## Applicant Response to the DOP&E letter 11.11.17

Development Application for Proposed Elgas Facility  
Part Lot 1 DP 1195449  
130 Cormorant Road, Kooragang NSW.

DEVELOPMENT: Liquified Petroleum Gas Storage Facility

REFERENCE: SSD 8448

Approved	Designed
Date	RJS
4th DECEMBER 2014	Drawn
Scale	AST
1 : 250 @ A1 1 : 500 @ A3	Checked
Project No.	Amdt.
14 - 002	GA - 01 DA3

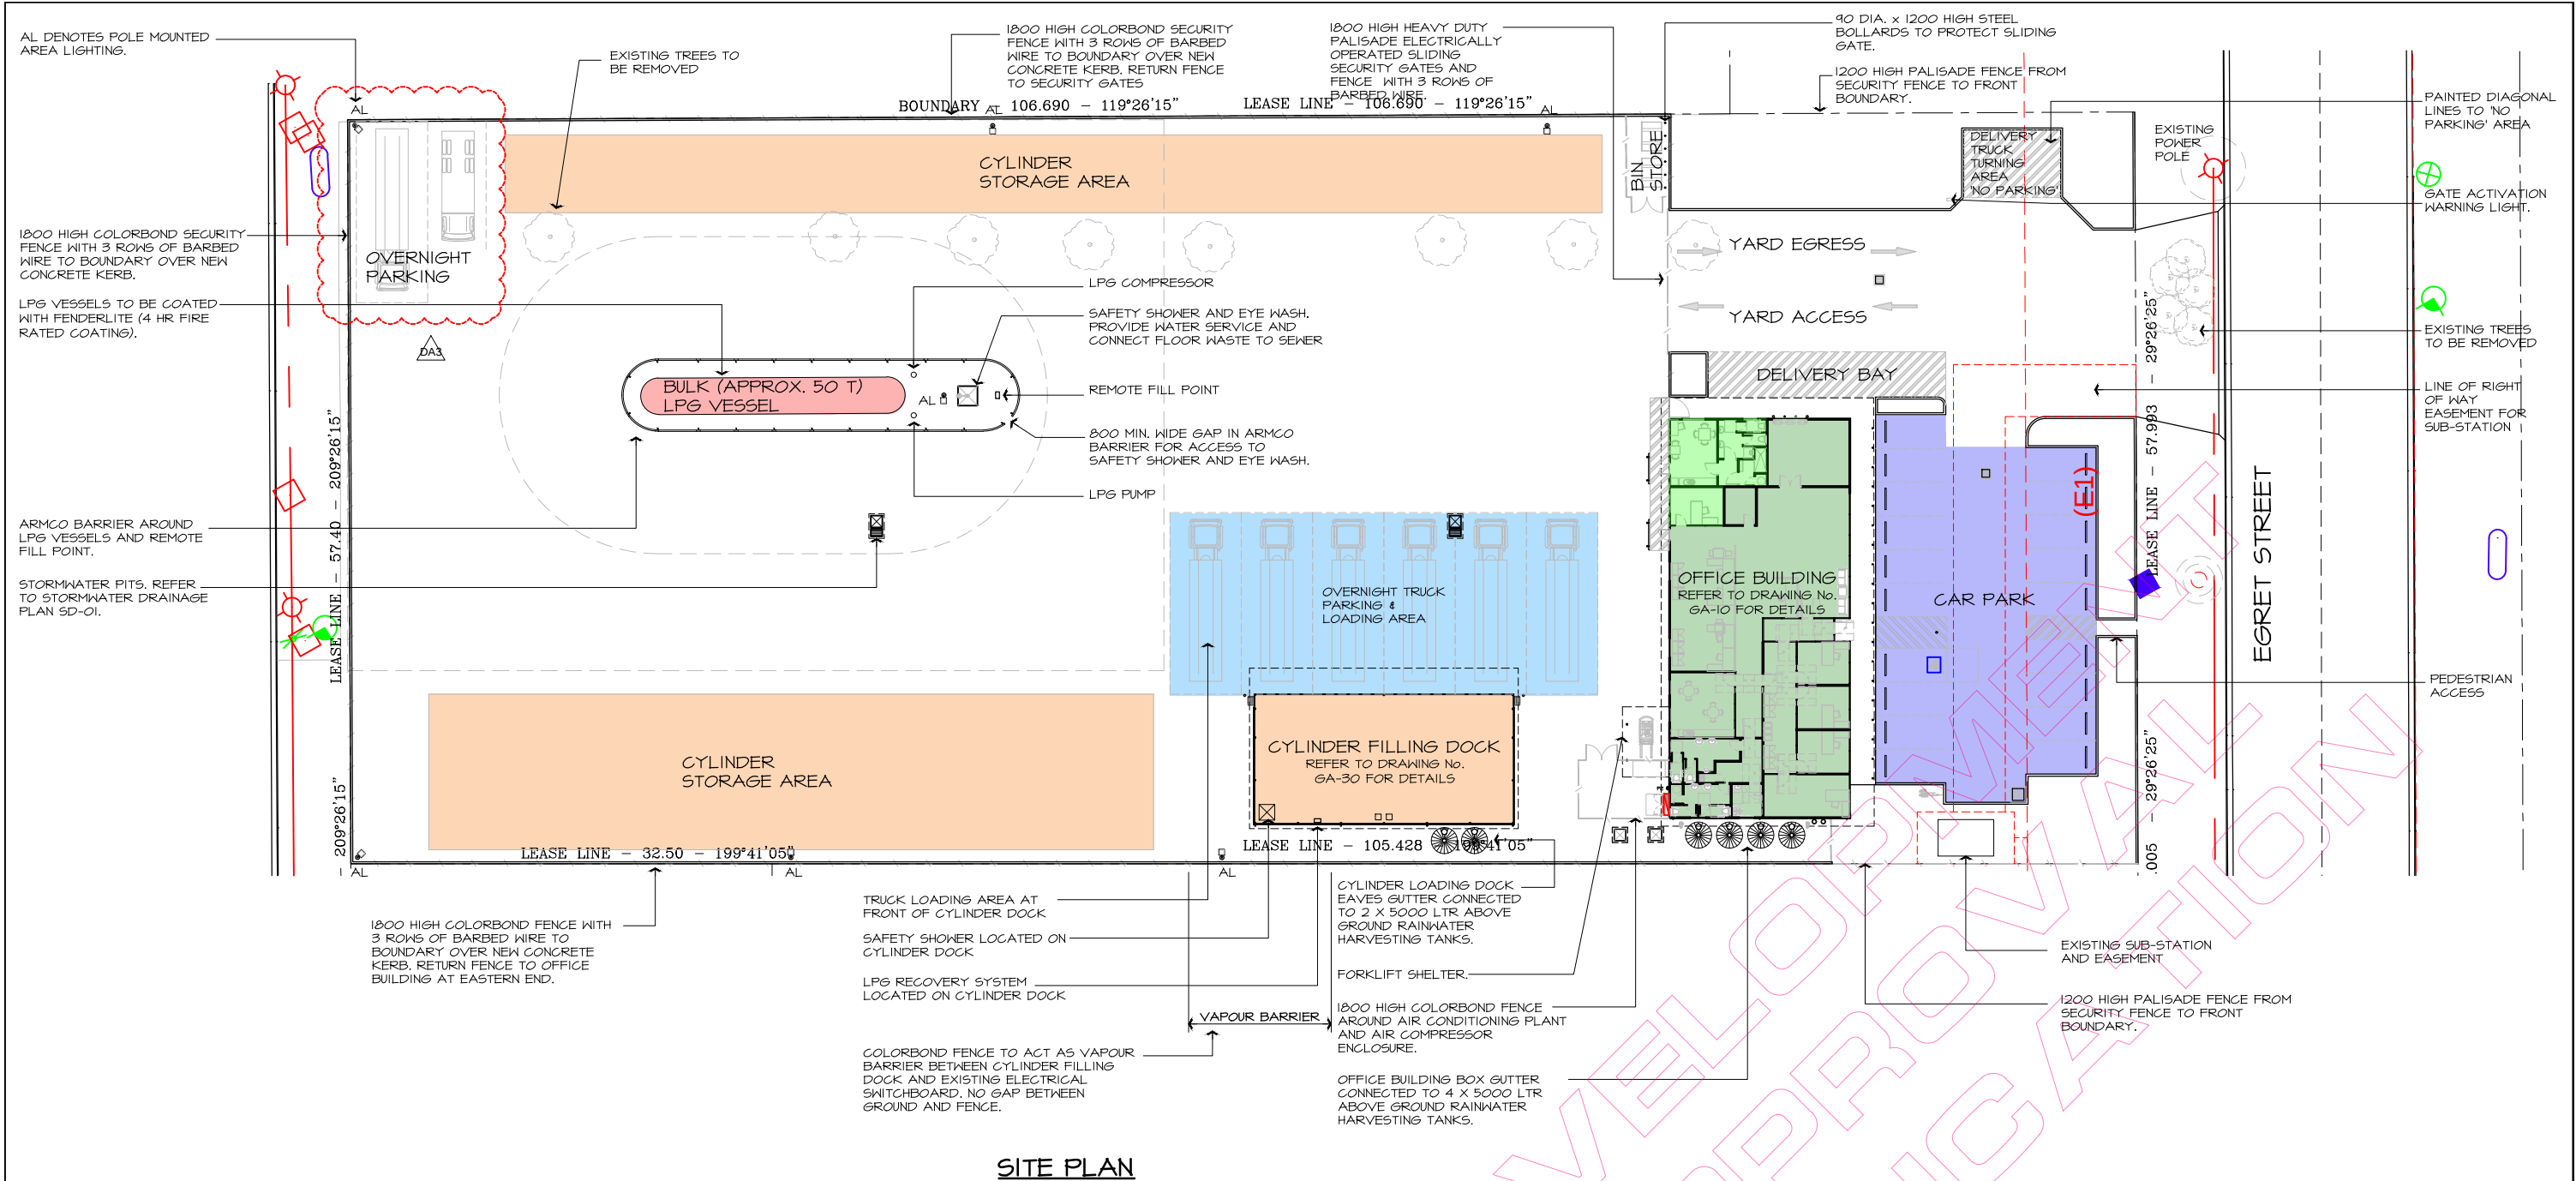
*Please revise the site plan to ensure all fully laden LPG tankers and cylinder trucks are parked in a direction that allows exit of the site in a forward direction.*

Site Plans have now been changed to ensure all heavy vehicles (loaded or unloaded) are parked in a direction that allows exit of the site in a forward direction.

1. 14 – 002 - GA - 01 Rev DA-3
2. 14 – 002 - GA - 02 Rev DA-3
3. 14 – 002 - GA - 03 Rev DA-3
4. 14 – 002 - TS - 01 Rev DA-3
5. 14 – 002 - TS - 02 Rev DA-3
